Application No: BE/115/20/HH
Site Address: 32 Norbren Avenue Bersted PO21 5HE
Description of works: Part two storey part single storey rear extension, first floor side extension and conversion of roofspace to habitable use and conversion of roof from hip to gable end

Thank you for your internet representation made on 17th December 2020 which has been recorded as an objection with the comments as follows:

DRAWING
Proposed plans

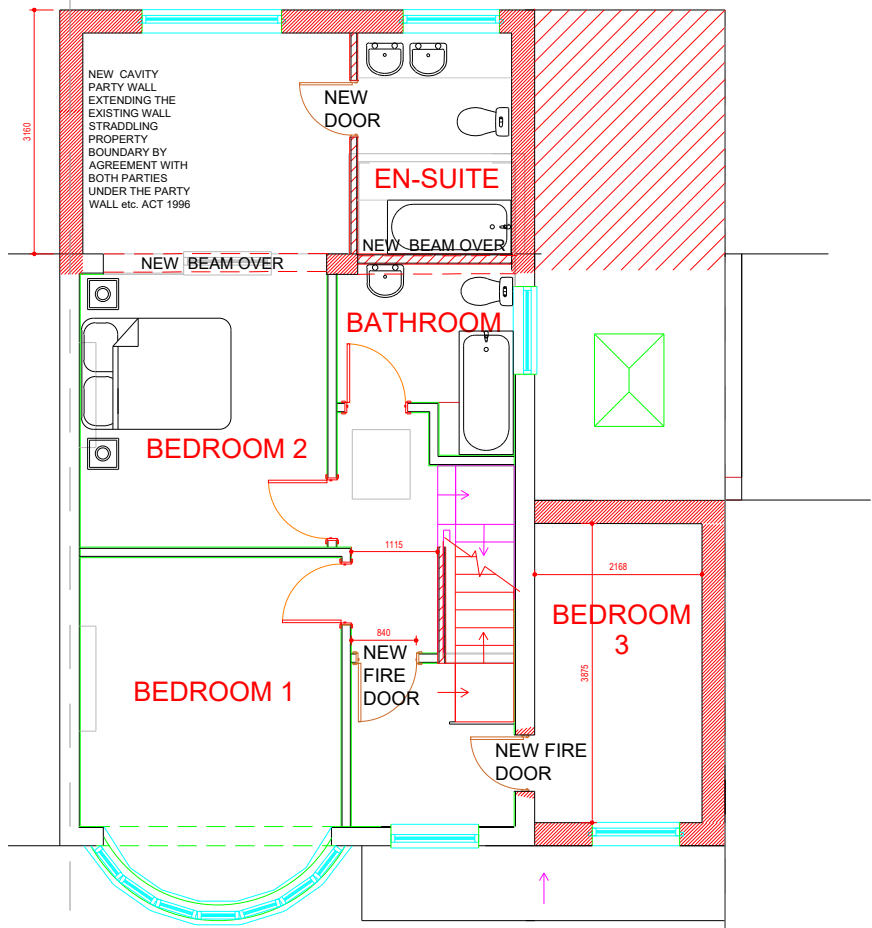
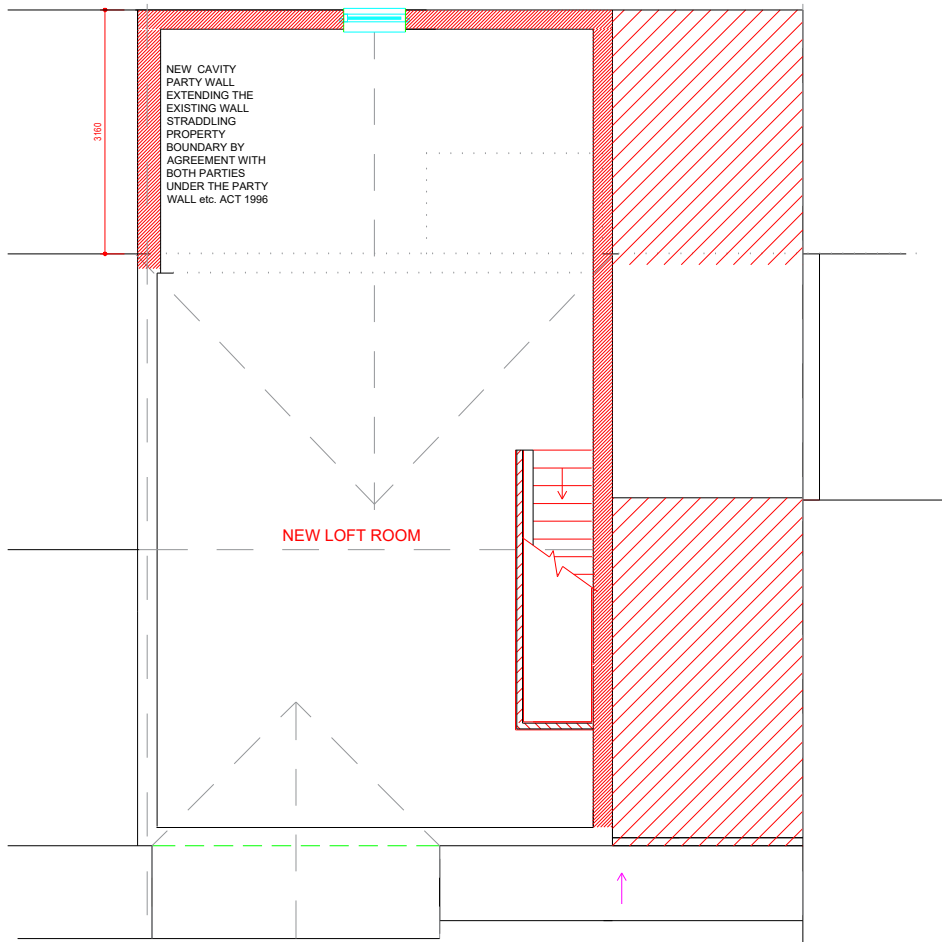
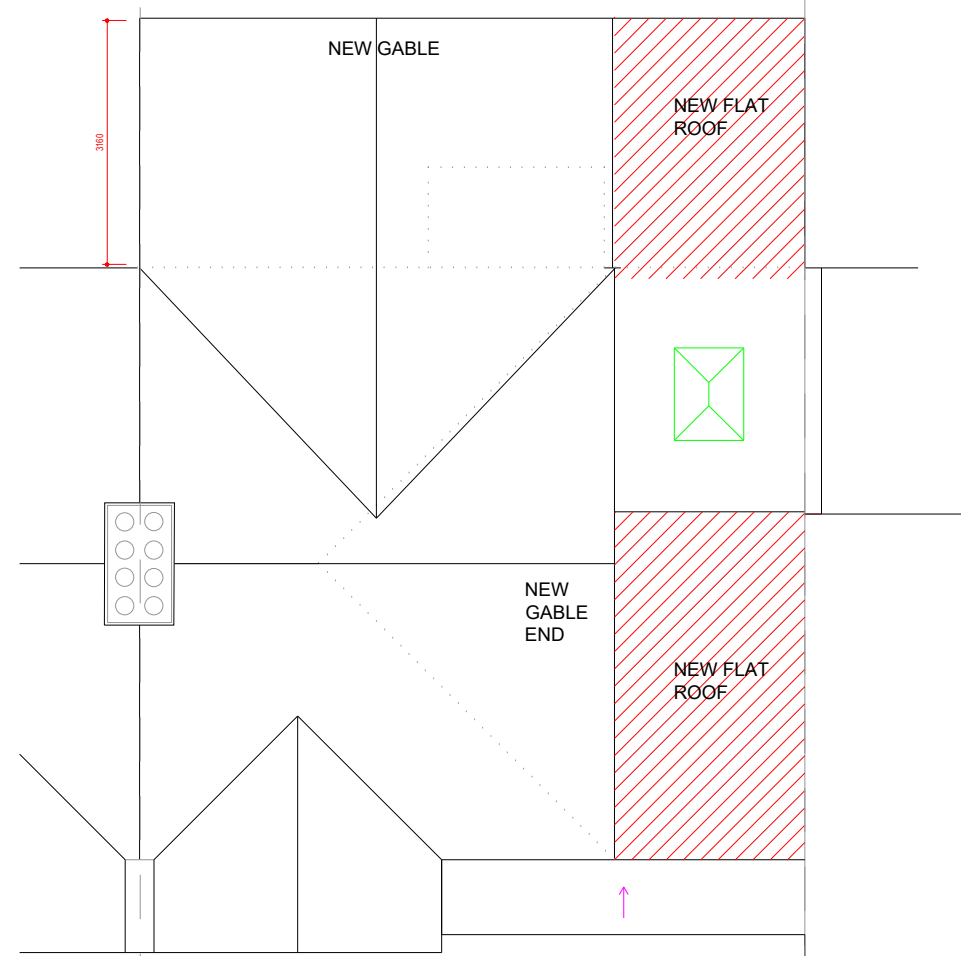
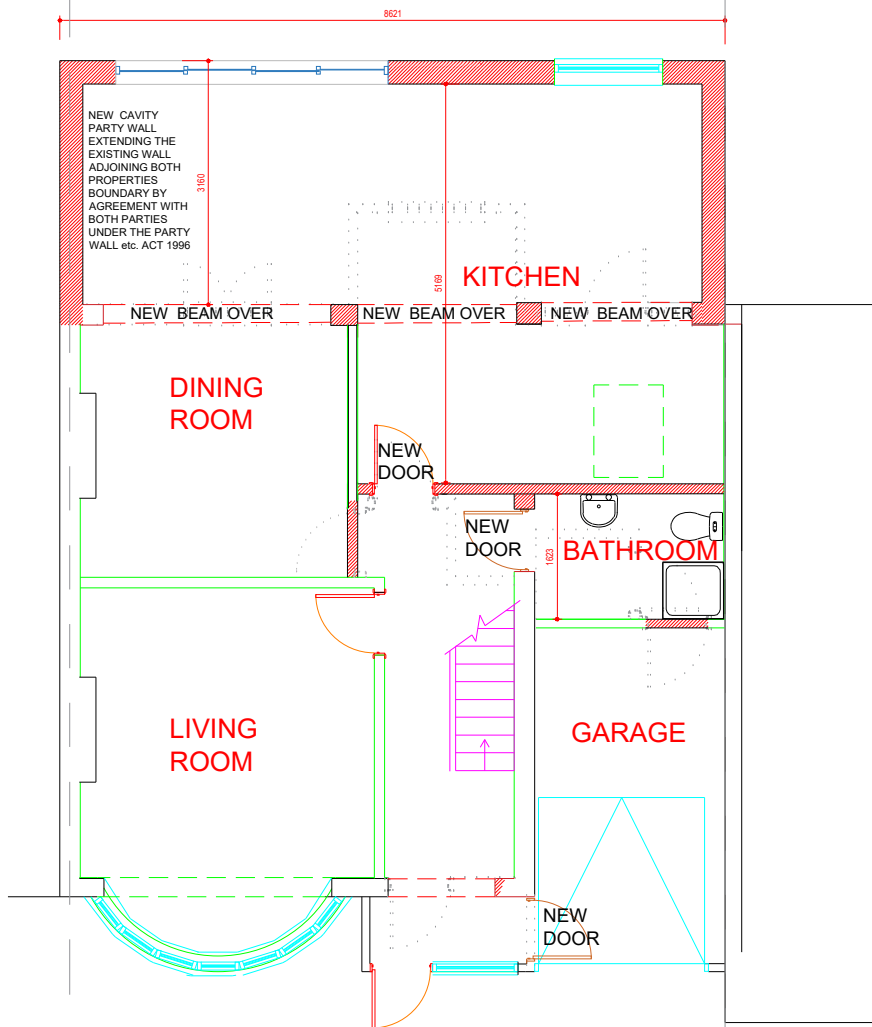
We have noticed on the plans reference to the party wall act. It states that the new cavity party wall extending the existing wall straddling property boundary by agreement with both parties under the party wall act. I would have expected any extension to be contained within the property boundary. We will need clarification as to what this actually means to us. I am concerned that there could be damage to our conservatory and if it will affect any future development from this side of the boundary.

I would not want any part of my property to be damaged. I am thinking specifically of the gutter on the side of the conservatory which, when it was constructed, doesn't overhang the boundary between the two properties. This may be something I would have to take up with my neighbour and that is the construction of a snow guard along the roof gutter which will be above our conservatory. This is to prevent tiles slipping and falling onto our conservatory roof and causing damage.

PROJECT	
32 Norbren Avenue	
Bognor Regis	
P021 5HE	
DRAWING	
Proposed Elevations	
SCALE 1:100 • A3	DATE July 19
DWG.NO. 1903-01-04	REV.

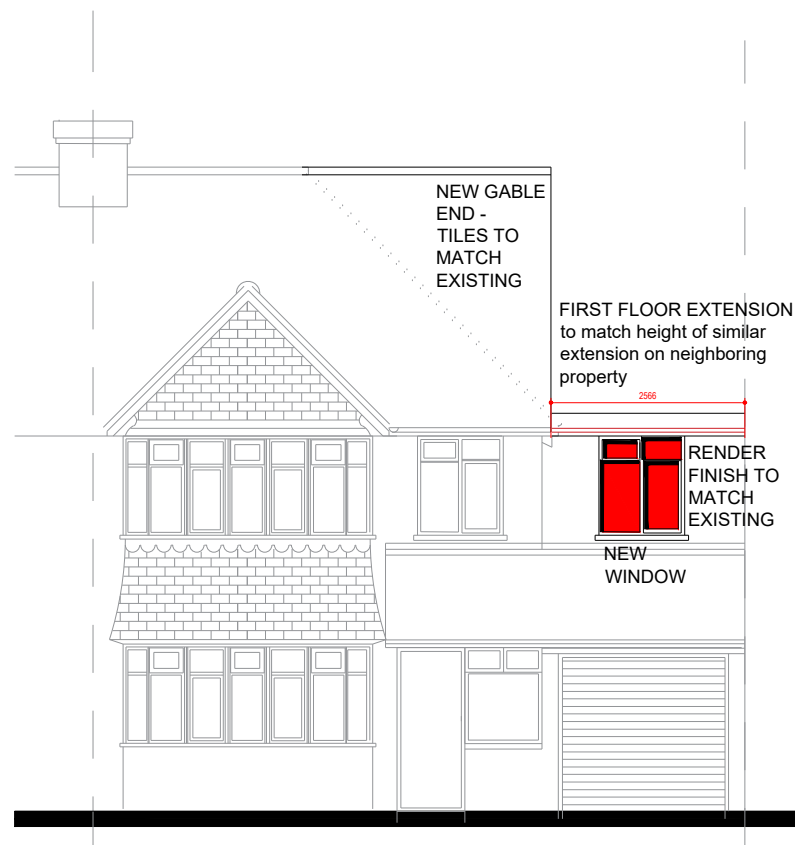
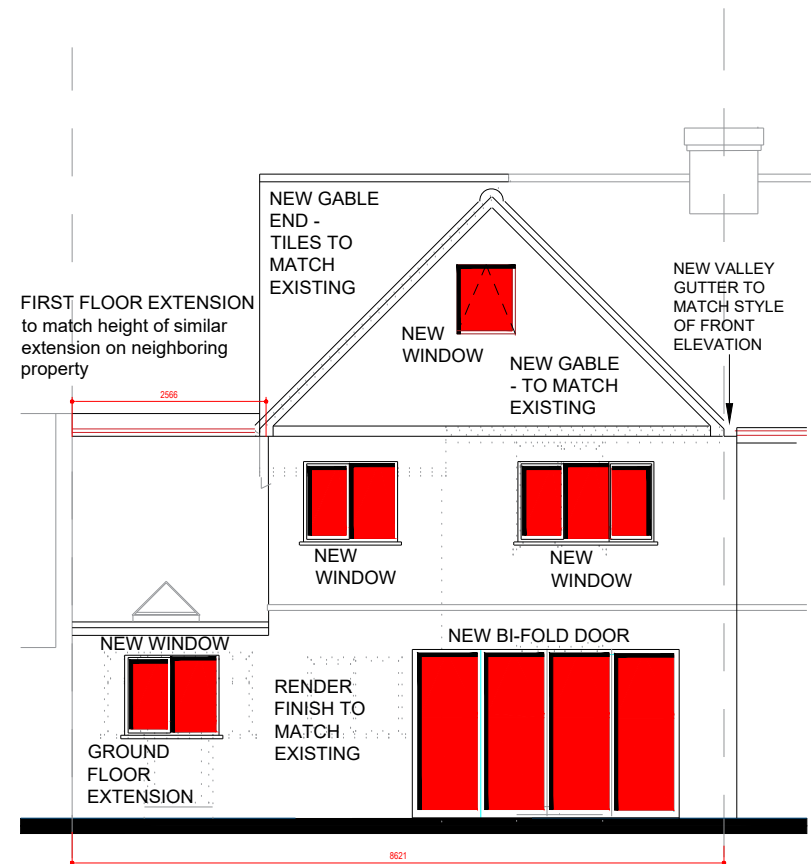
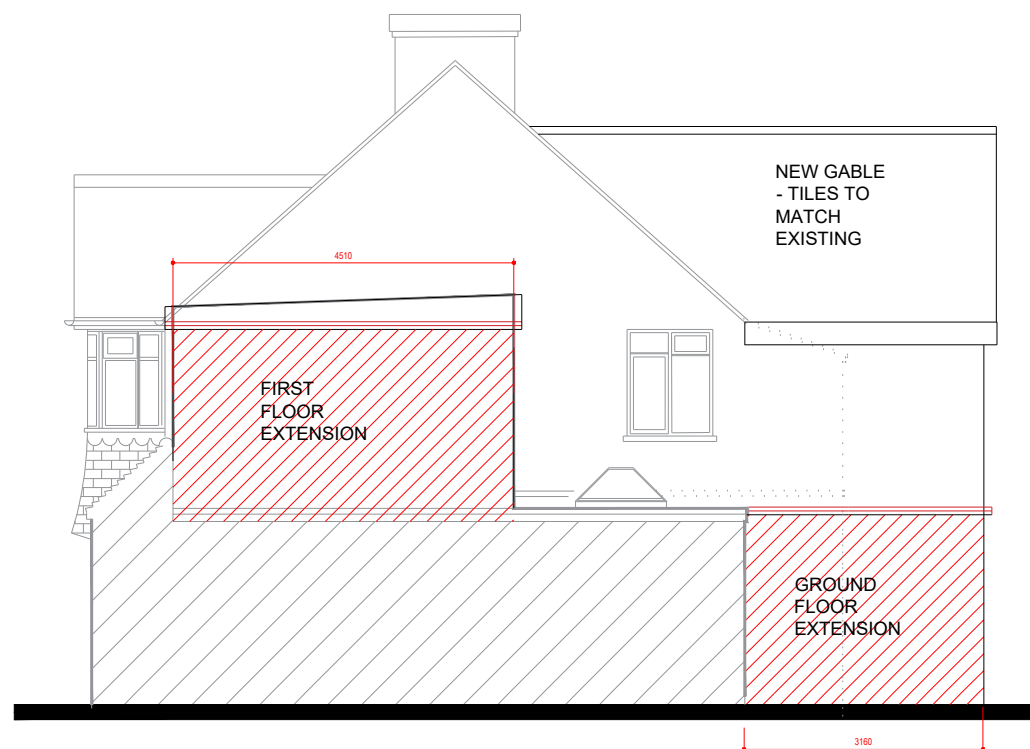
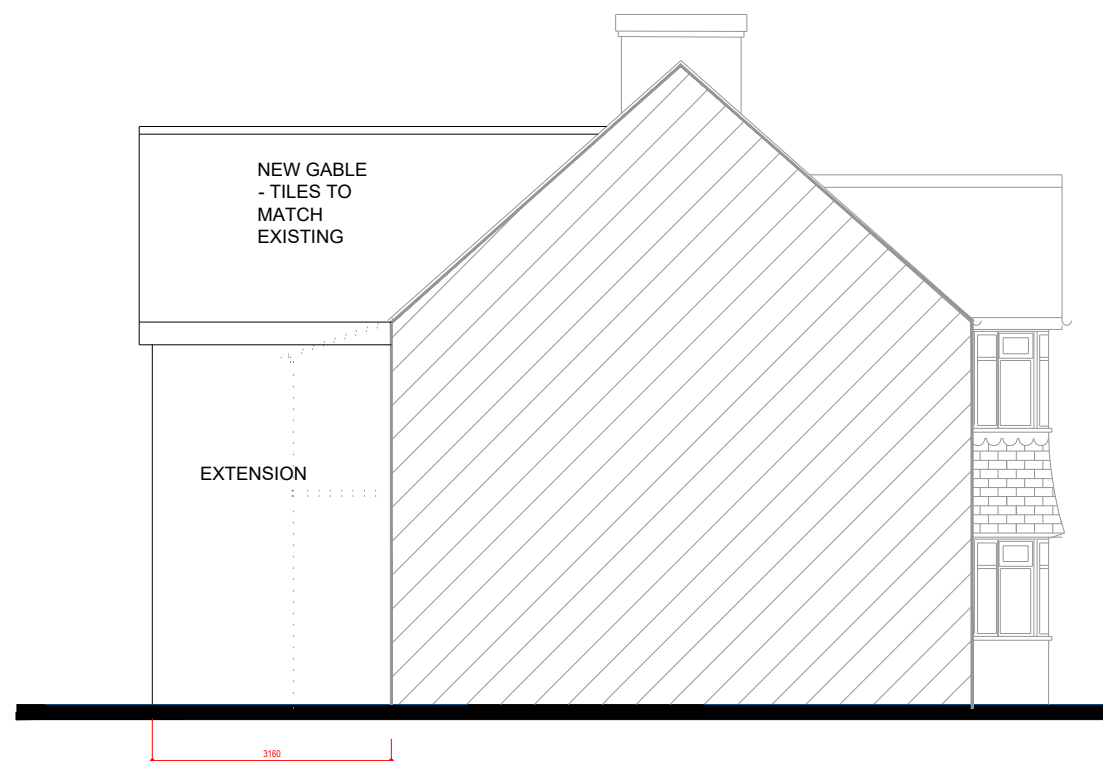
The wall which would overlook our conservatory I feel should be rendered and painted white as this will alleviate the problem of loss of light to the back bedroom.
